Item No. **Report of the Head of Planning, Transportation and Regeneration**

Address 251 LONG LANE HILLINGDON

Development: Sub-division of plot and erection of 1 x 2-bed dwelling (Use Class C3), landscaping, and associated works

LBH Ref Nos: **76753/APP/2021/3469**

Figure 9: Extract of site plan showing landscaped garden area and patio

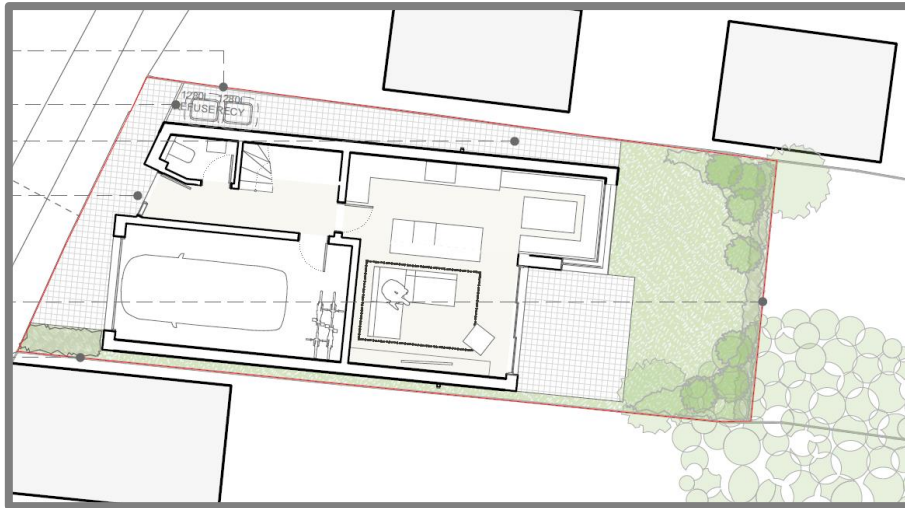
Policy DMHB 18: Private Outdoor Amenity Space states: All new residential development and conversions will be required to provide good quality and useable private outdoor amenity space. Amenity space should be provided in accordance with the standards set out in Table 5.2.

From this table it is confirmed that a two bedroom dwelling is required to provide 60 square metres. The proposal would only result in a private rear garden area measuring 37 square metres. The proposal therefore fails to provide amenity space of sufficient size and quality commensurate to the size and layout of the said unit, in conflict with this policy and having implications for the quality of accommodation on site.
